ENGINEER'S SEAL	Discount Towing 109 Headingly Ave. NW	DRAWN BY RHD
	GRADING AND DRAINAGE PLAN	DATE 9-01-15
	RHD Engineering, LLC 4305 Purple Sage Ave. NW ALBUQUERQUE, NM 87120 (505) 288-1621	SHEET # 1 of 1
Richard Dourte P.E. #10854		JOB #

Discount Towing
109 Headingly Ave. NW
Albuquerque, New Mexico

**RE: Discount Towing
109 Headingly NW
Grading and Drainage Plan
Engineers Stamp Date 9/1/15 (G15D0201)**

ENGINEER'S SEAL	Discount Towing 109 Headingly Ave. NW	DRAWN BY RHD
	GRADING AND DRAINAGE PLAN	DATE 9-01-15
	RHD Engineering, LLC 4905 Purple Sage Ave. NW ALBUQUERQUE, NM 87120 (505) 288-1621	SHEET # 1 of 1
	Richard Dourte P.E. #10854	JOB #

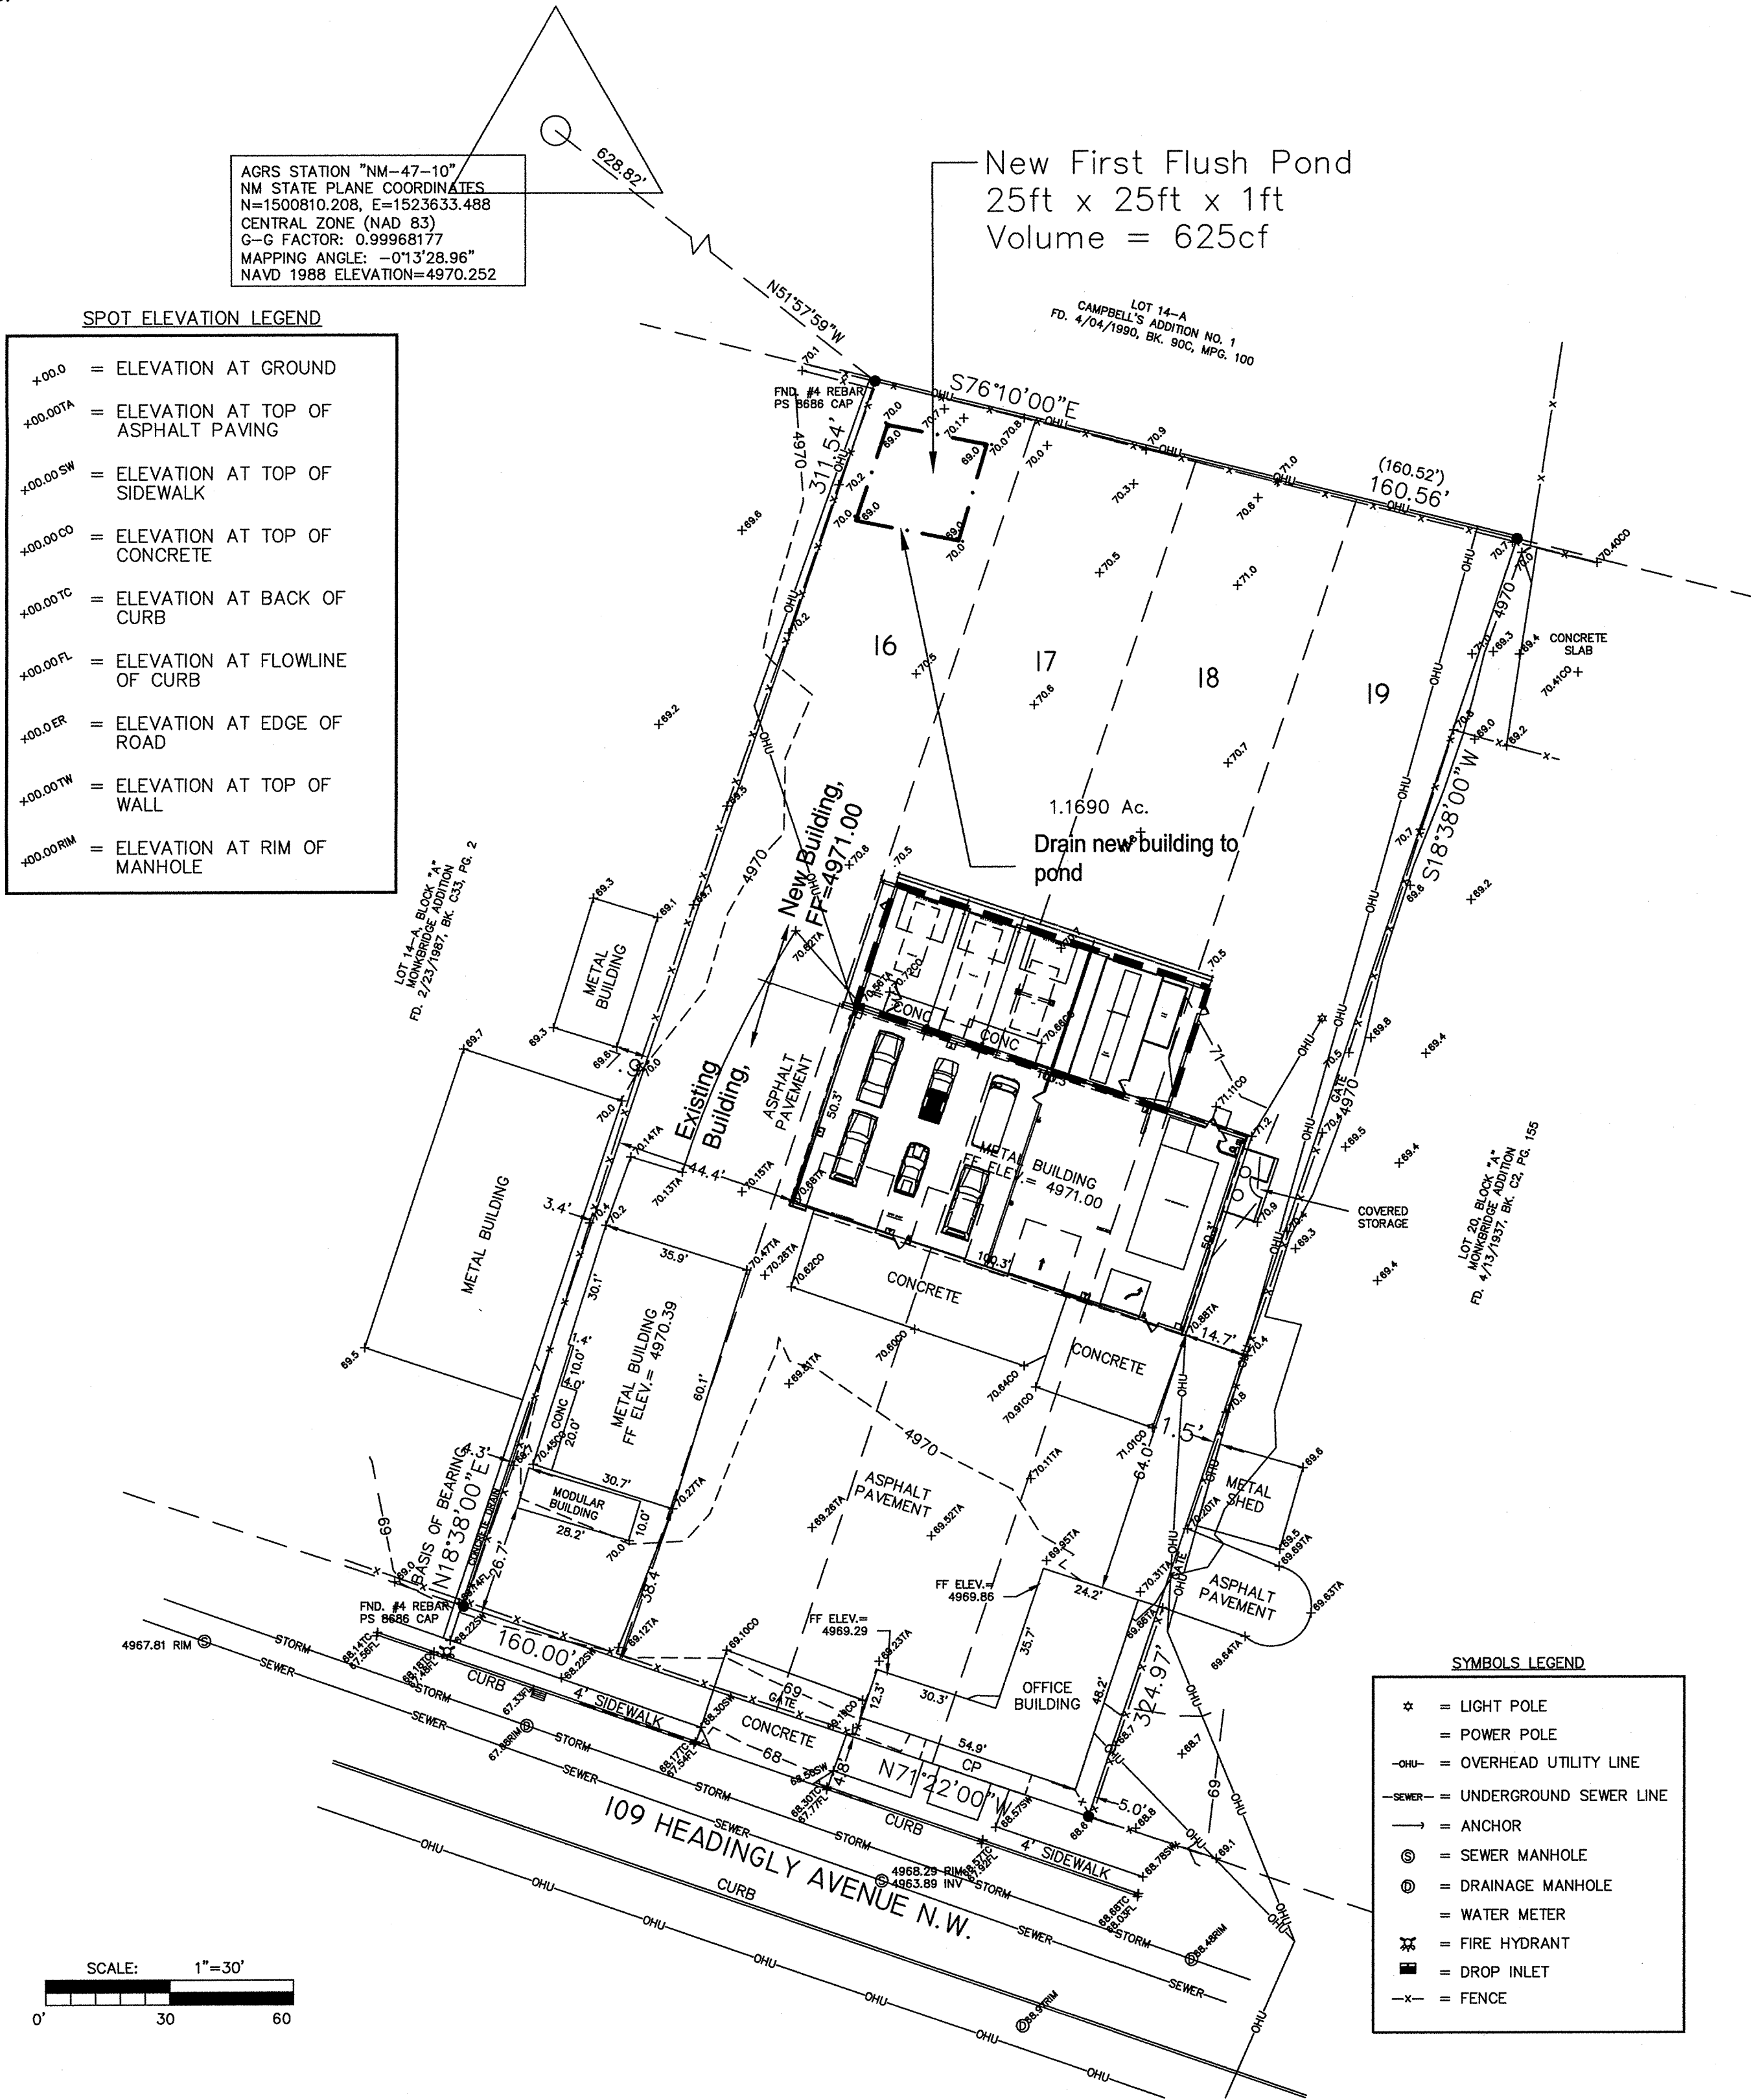
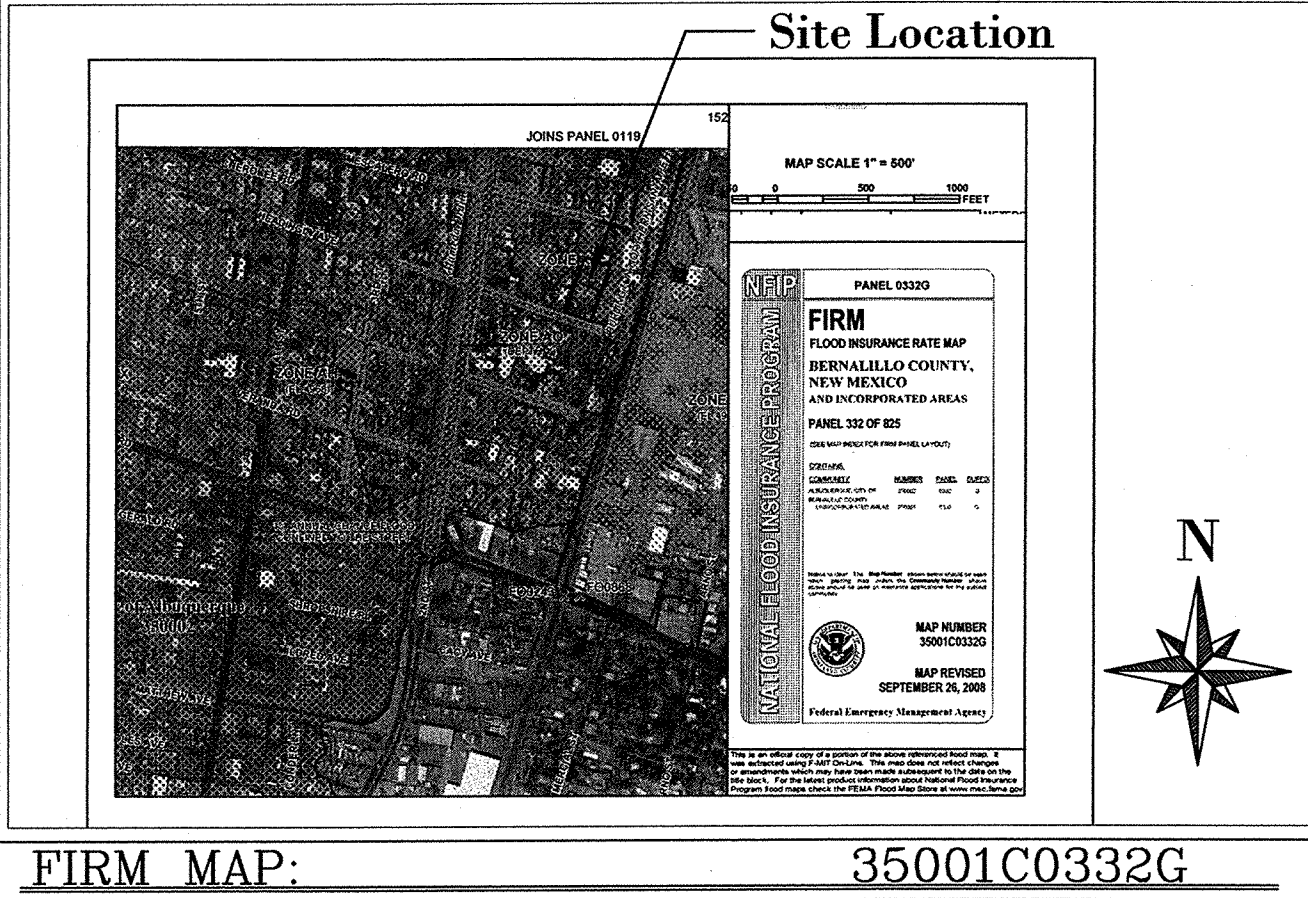
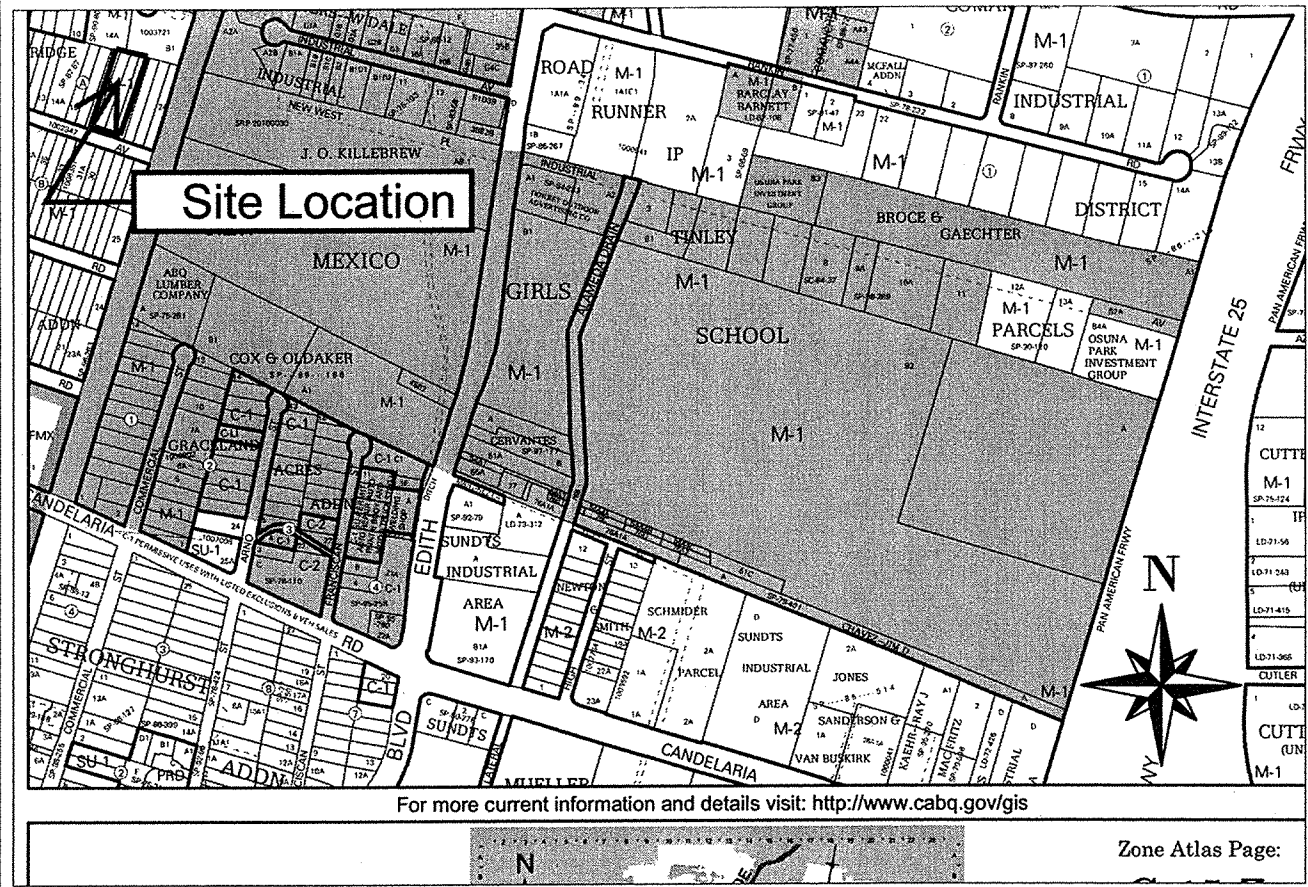
- Provide emergency overflow/calculations.
- Where does the runoff go once it exceeds its capacity?
- Provide how offsite flows are being handled.
- Provide different line weights for existing buildings and the new building.
- Clearly show proposed and existing spot elevations and topography.
- Is re-plat required for the removal of the lot lines?
